Plat Redlines Comment Responses.pdf Markup Summary

[PrimarySort] 6-3-2024

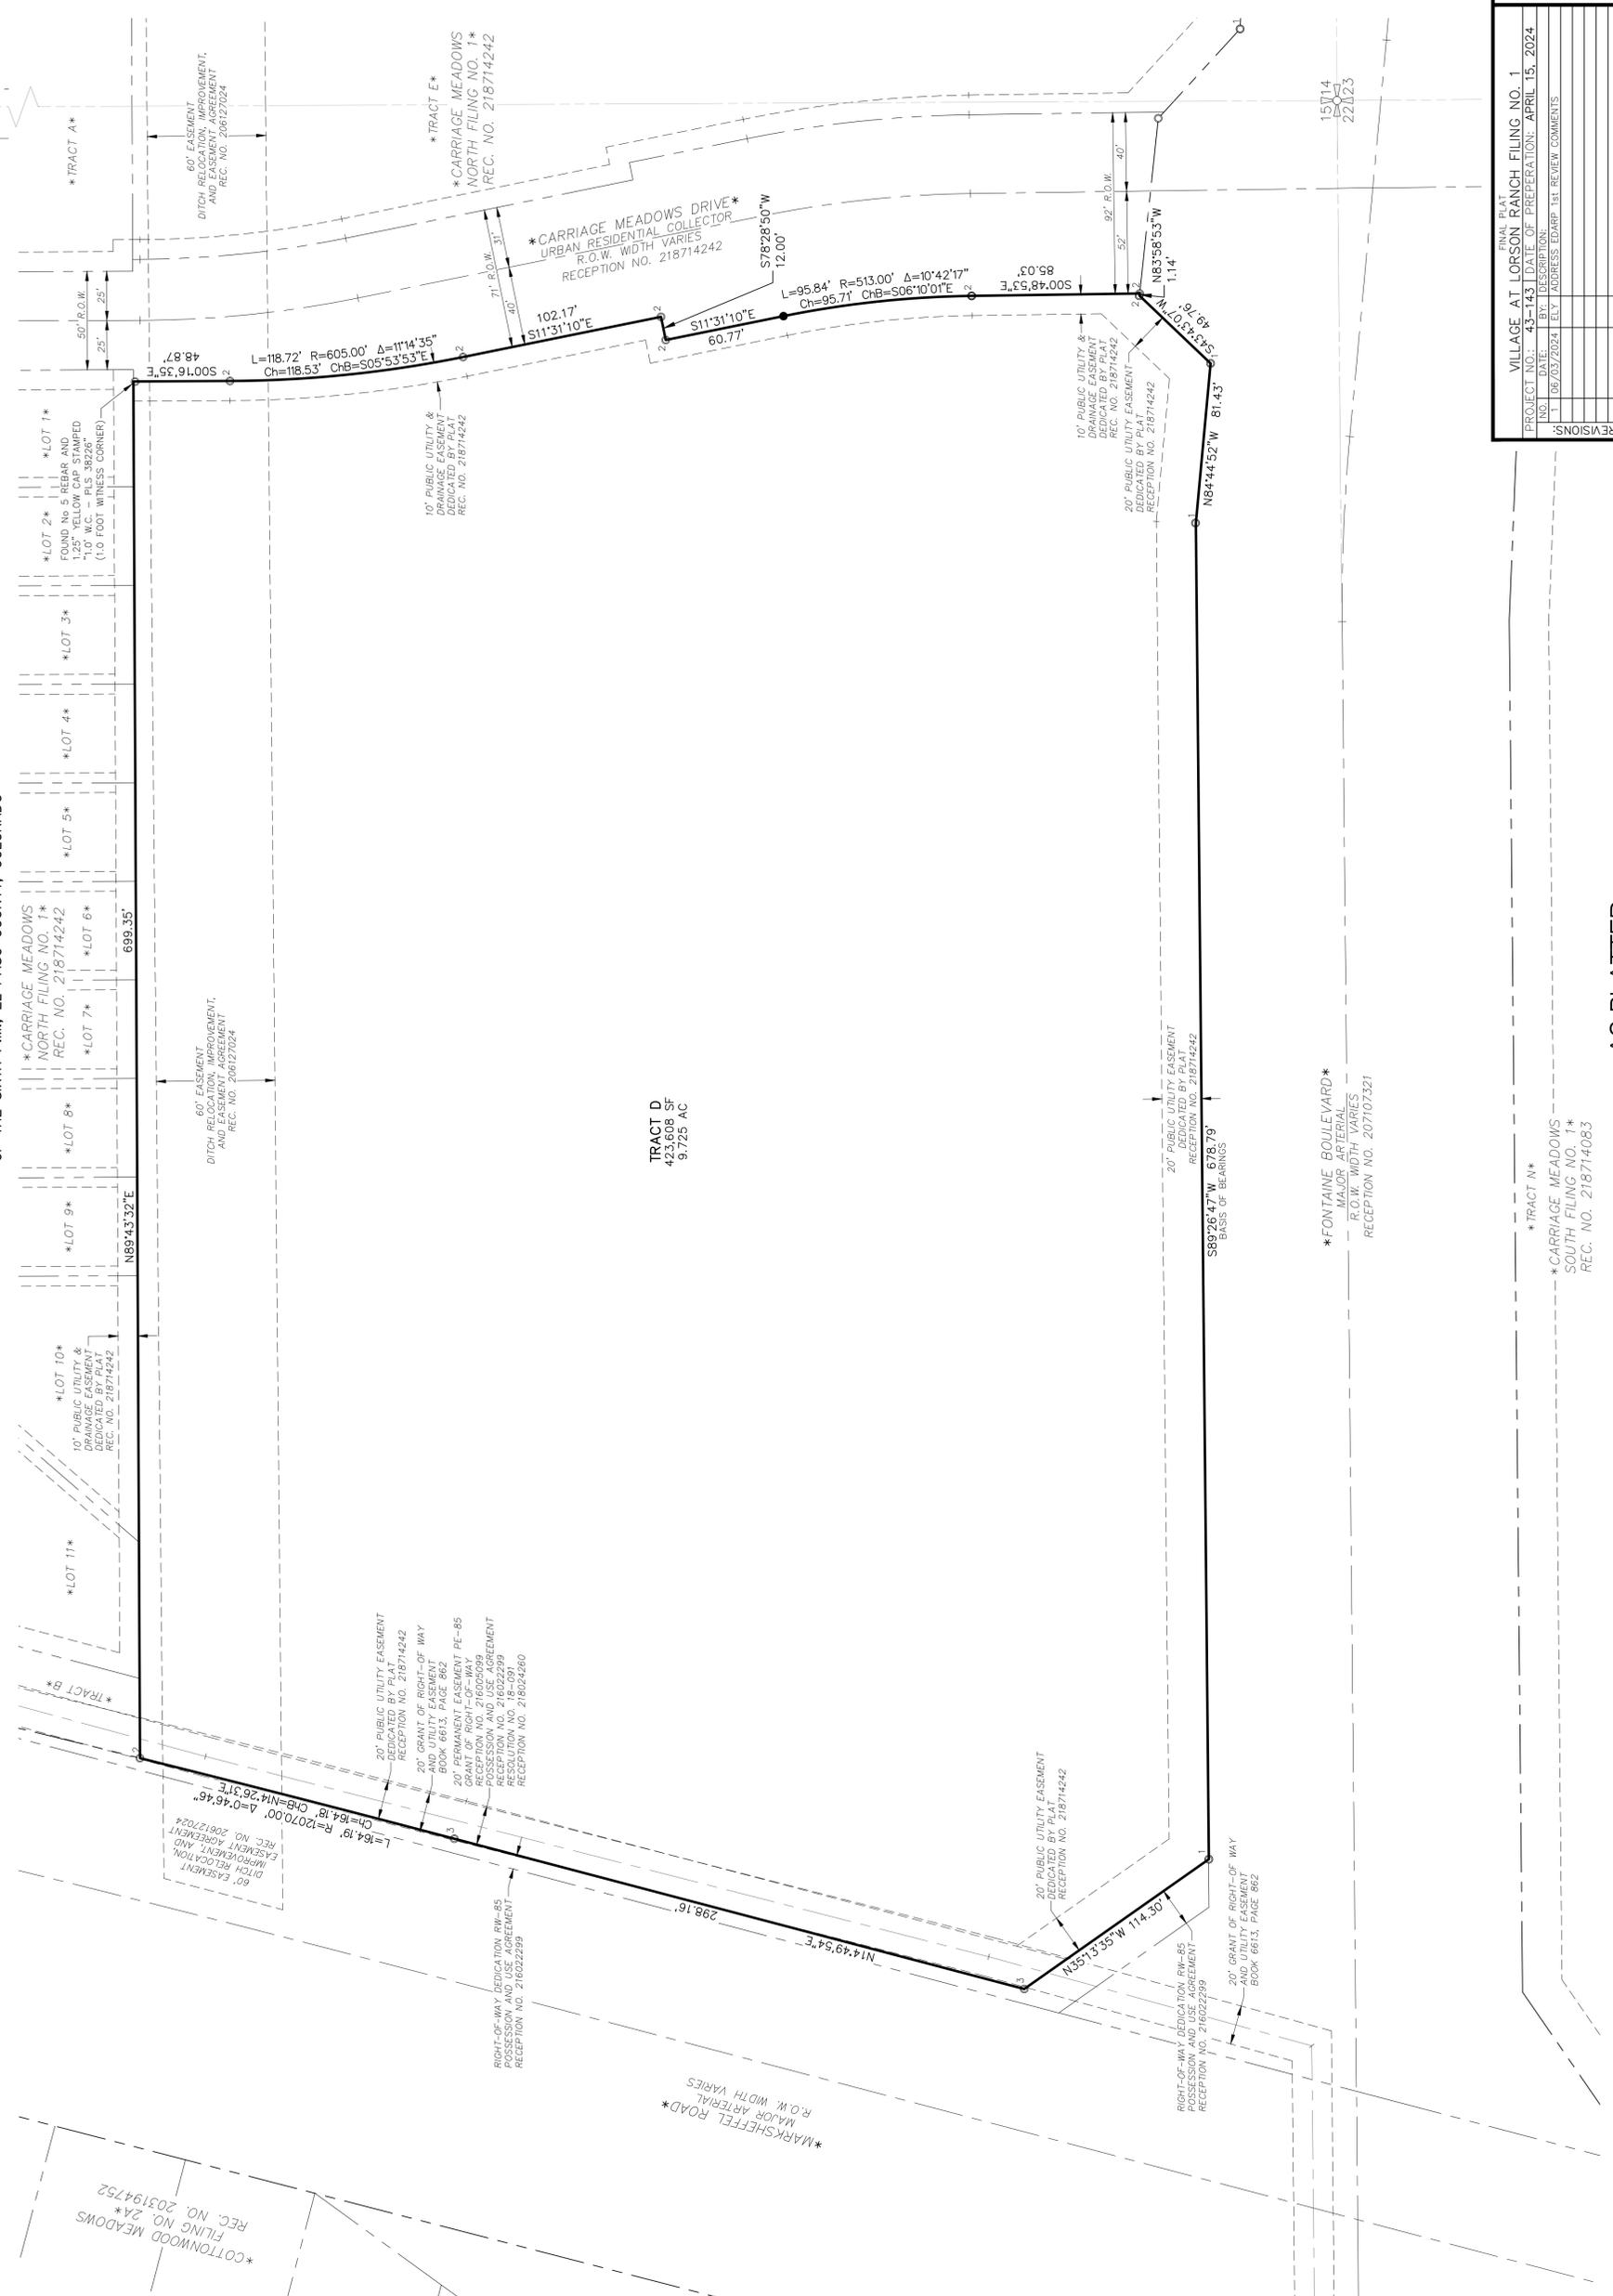
Per LDC any road servicing more than 3 lots needs to be a road, please state if this is a public or private road. If private need waiver 8.4.4

Access easement identified as a private road
